POST-EPC MEMORANDUM

RE: Paradise RV Park (formerly West Mesa RV Park)

Project #1008830/11EPC-40073 – Site Development Plan for Building Permit

LS-101

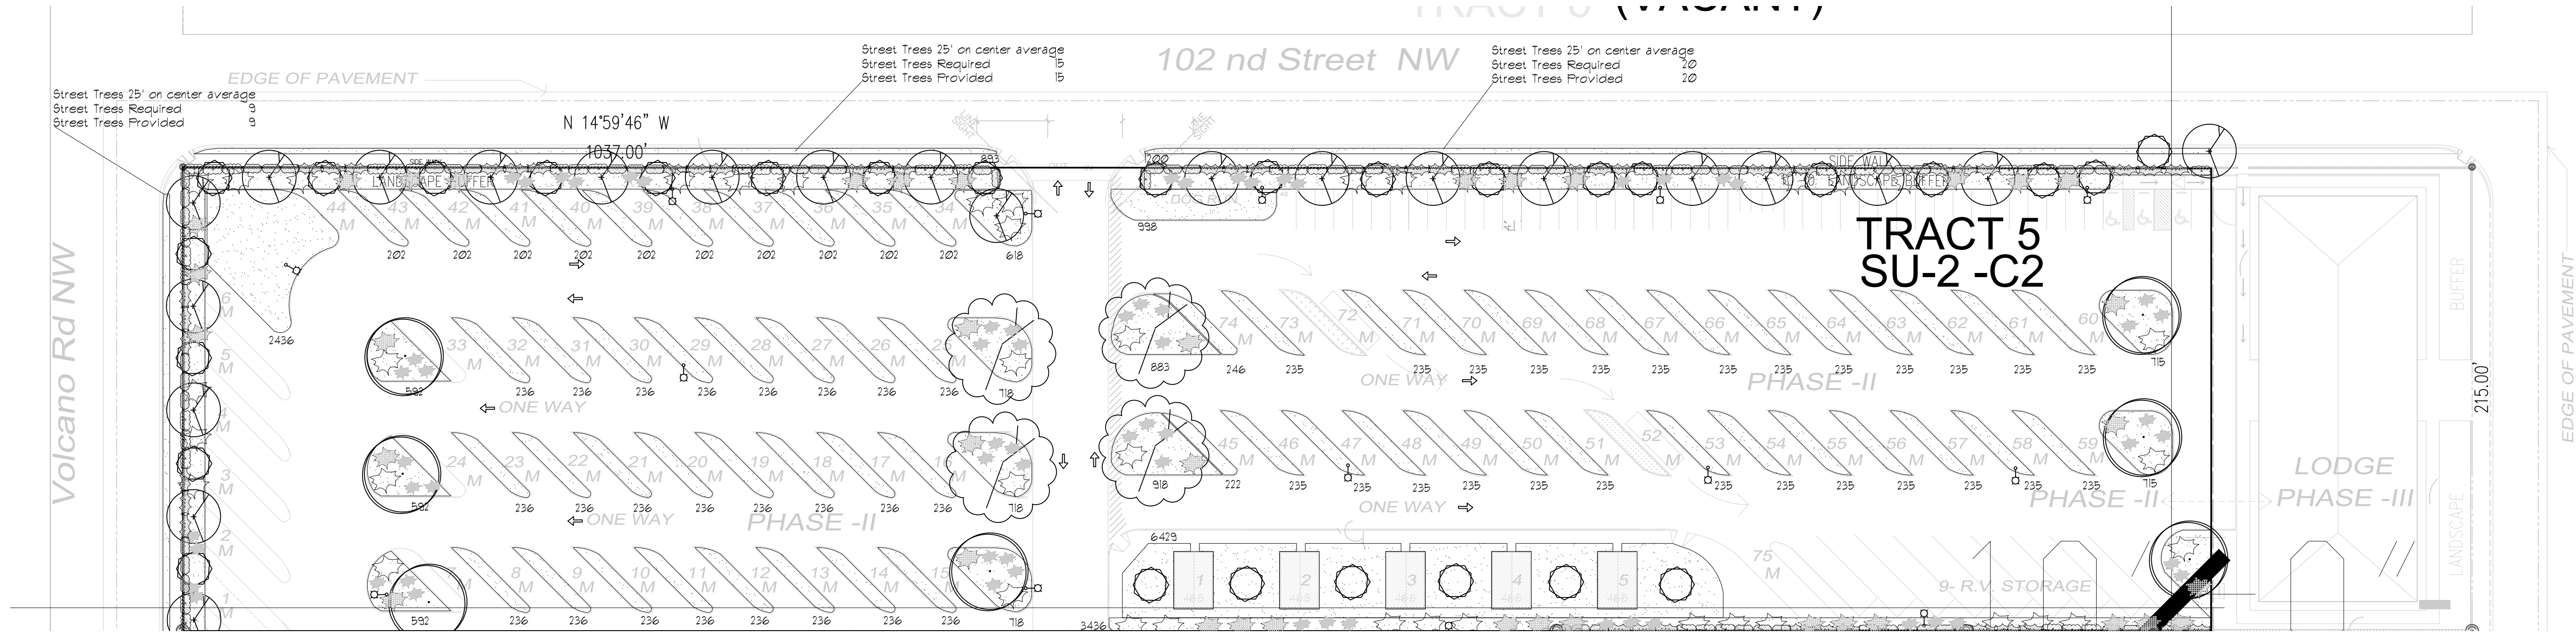
4. Condition 4 has been met. A note indicating the site will comply with Area Lighting Regulations was added to Sheet SP-2.
5. Condition 5 has been met. The quantity of each type of planting and the dimensions of the landscaping beds for Phase II have been provided on Landscape Plan Sheet LS-101. Although Sheet LS-102 is referenced in the post-EPC letter, but it was not submitted with the drawing set. Note that Sheet LS-101 and LS-102 are identical. Please resubmit Sheet LS-102.

SP-1

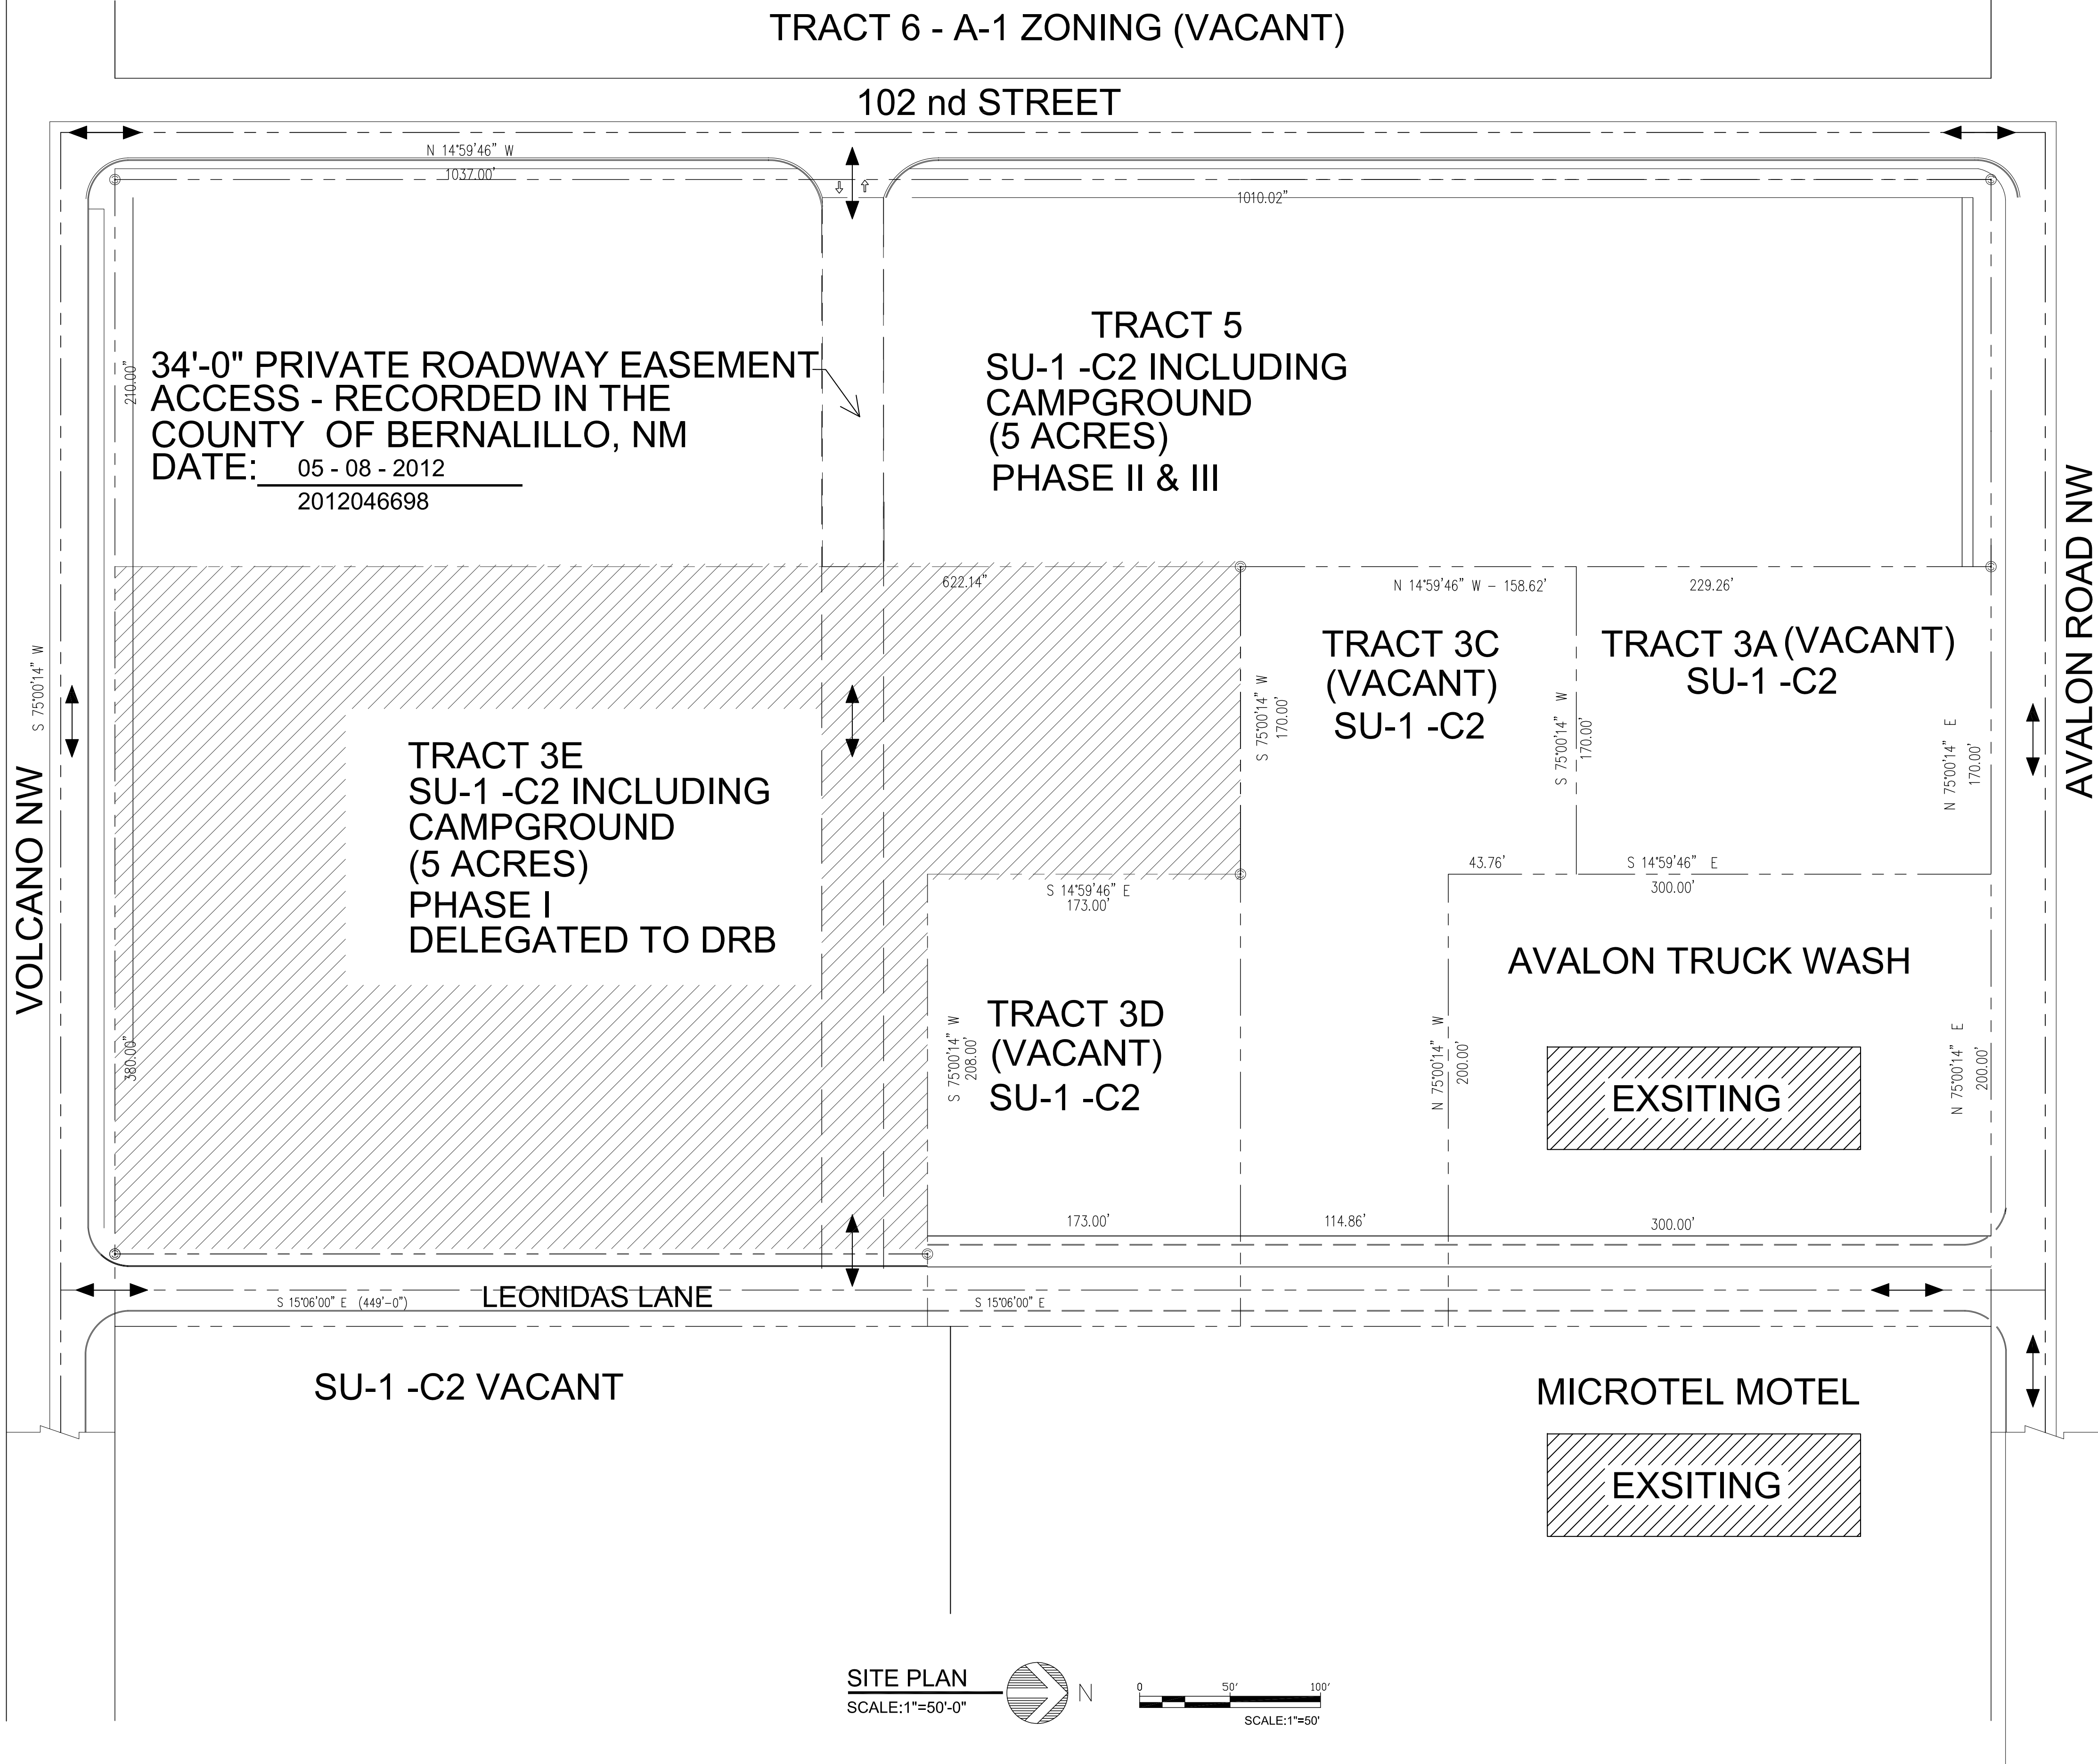
- 8a. The 34' wide road access easement is shown on the site development plan Sheets SP-1 and SP-2. The 34' wide road access easement is shown as referenced in Keyed Note #17 on Sheet SP-2.

- 8i. Access Easements are labeled and shown on Site Development Plan Sheets SP-1 and SP-2.
 - 8j. An Infrastructure List with all offsite improvements have been provided by the applicant.
